**To:** FILE  
**From:** Jean Fraser  
**Subject:** Application ID: 2013-268  
**Date:** 1/23/2014

**From:** Tom Errico <thomas.errico@tylin.com>  
**To:** Jean Fraser <JF@portlandmaine.gov>  
**CC:** David Margolis-Pineo <DMP@portlandmaine.gov>, Katherine Earley <KAS@portlandmaine.gov>, Jeff Tarling <JST@portlandmaine.gov>, "JeremiahBartlett" <JBartlett@portlandmaine.gov>  
**Date:** 1/23/2014 9:51 AM  
**Subject:** Capisic Pond Improvements Project

**From:** Tom Errico <thomas.errico@tylin.com>  
**To:** Jean Fraser <JF@portlandmaine.gov>  
**CC:** David Margolis-Pineo <DMP@portlandmaine.gov>, Katherine Earley <KAS@port...>  
**Date:** 3/20/2014 3:15 PM  
**Subject:** Capisic Pond Project

**G-001**

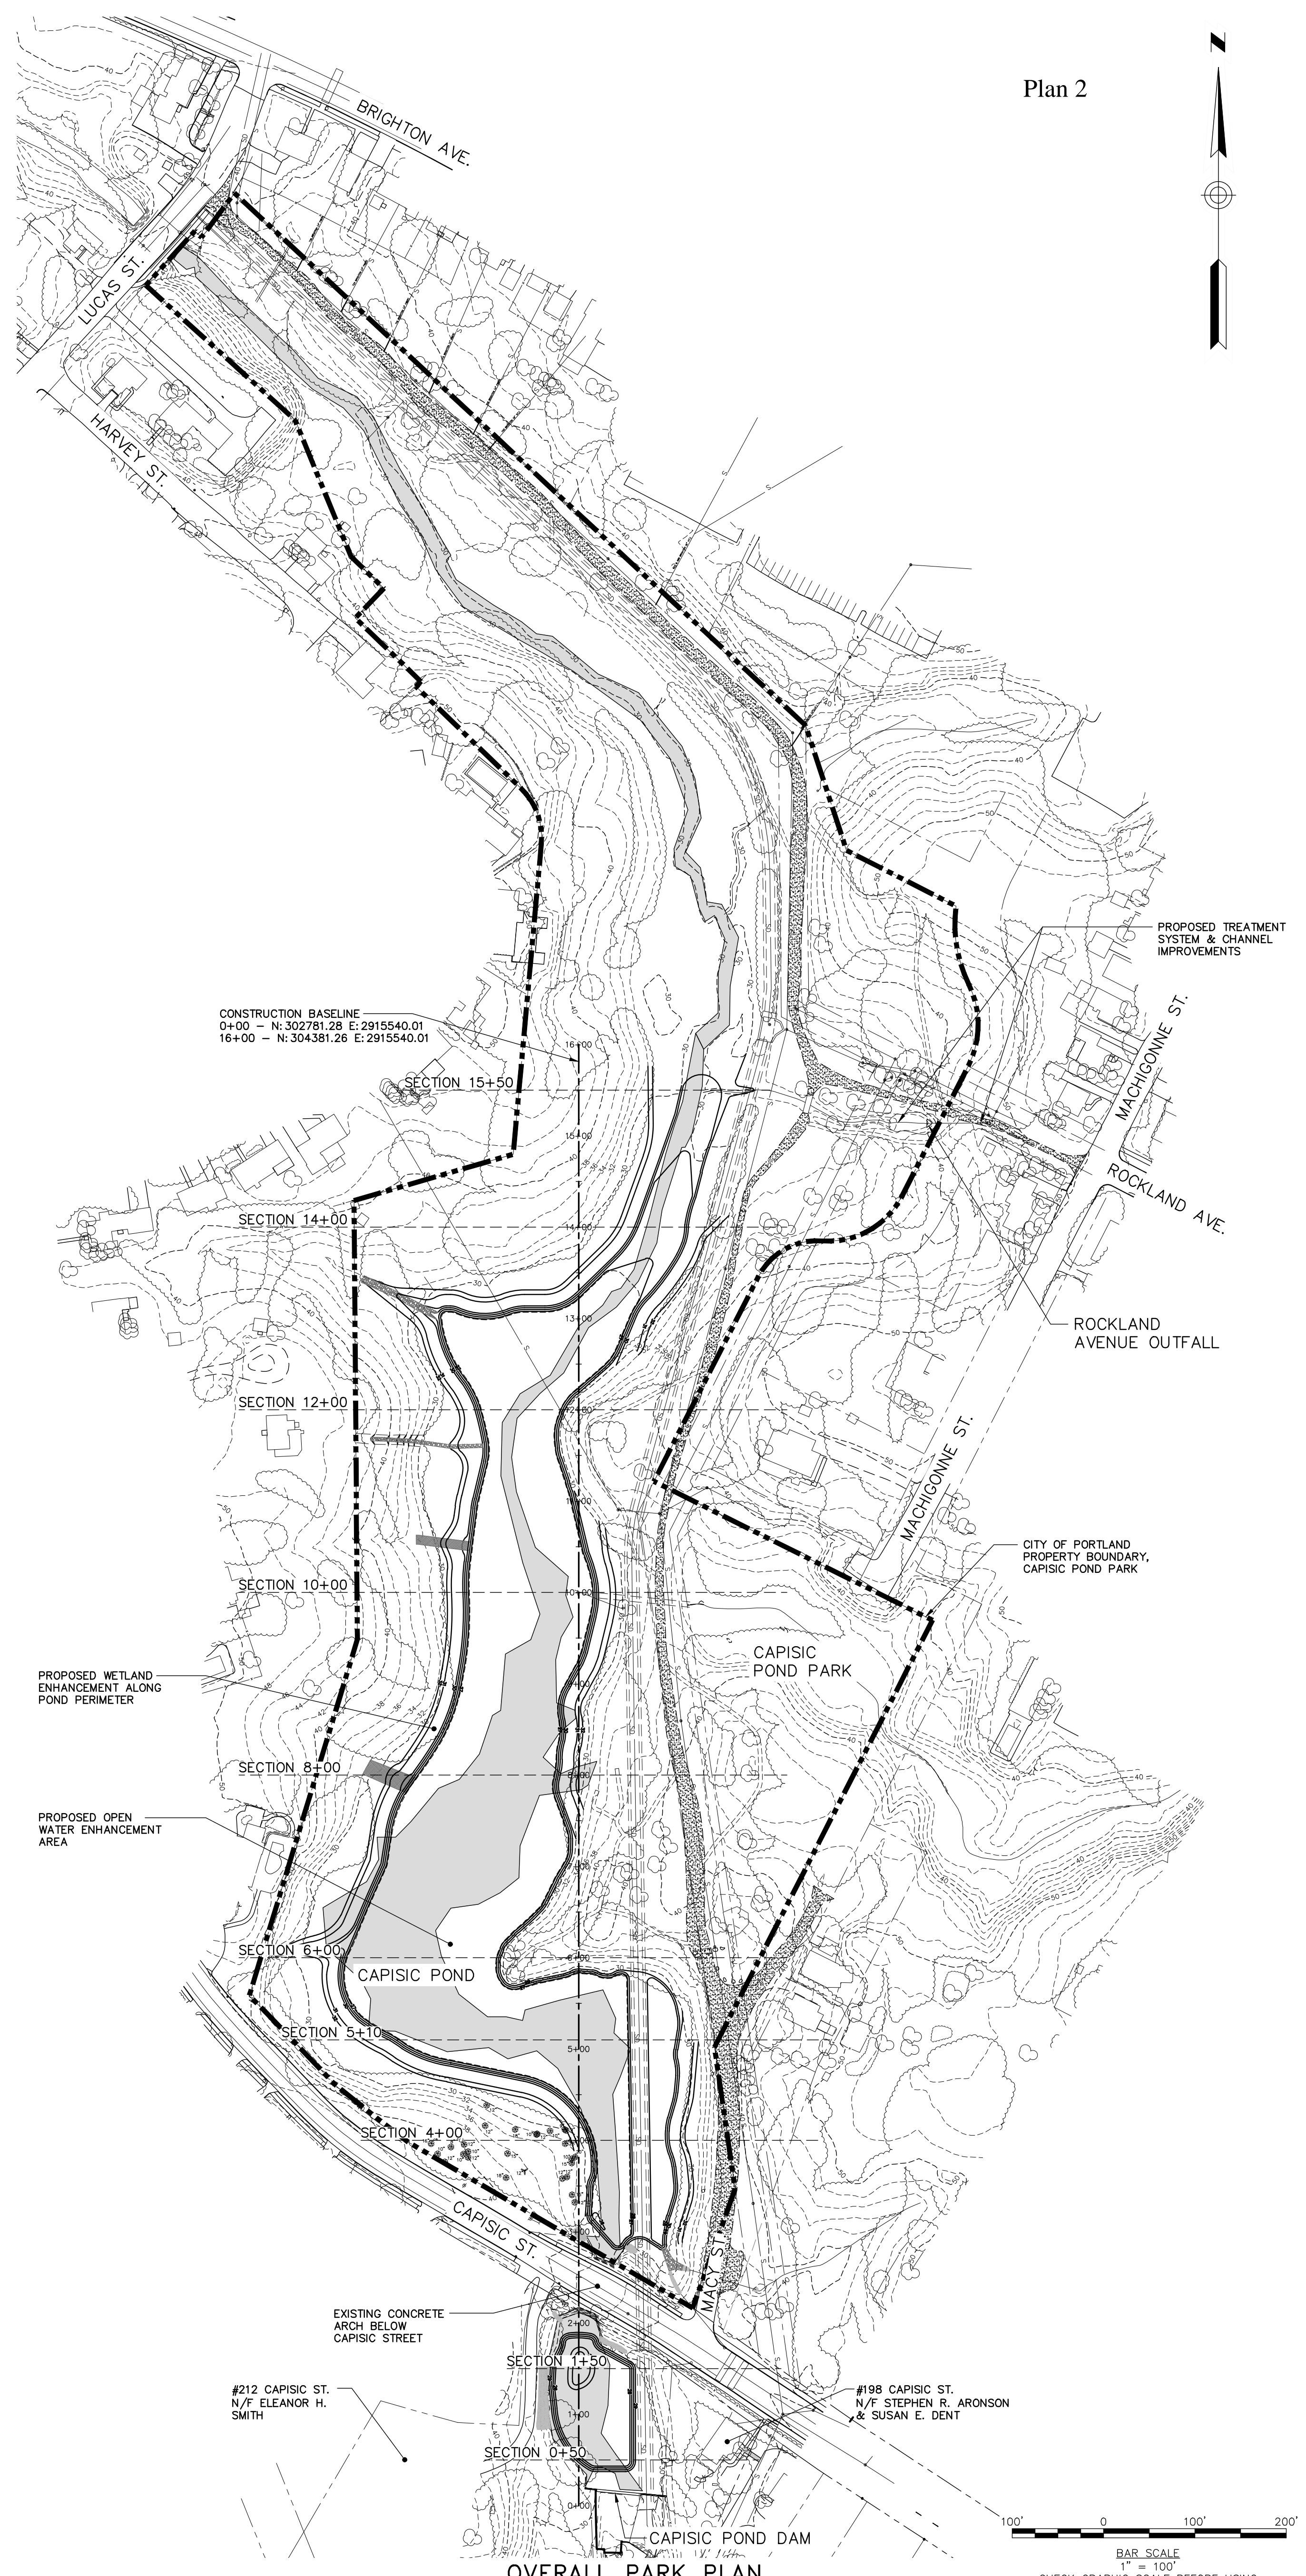
Please add a note to the plans stating that "The Contractor shall be responsible for any sweeping due to materials inadvertently falling on the roadway between the dredge and disposal site."
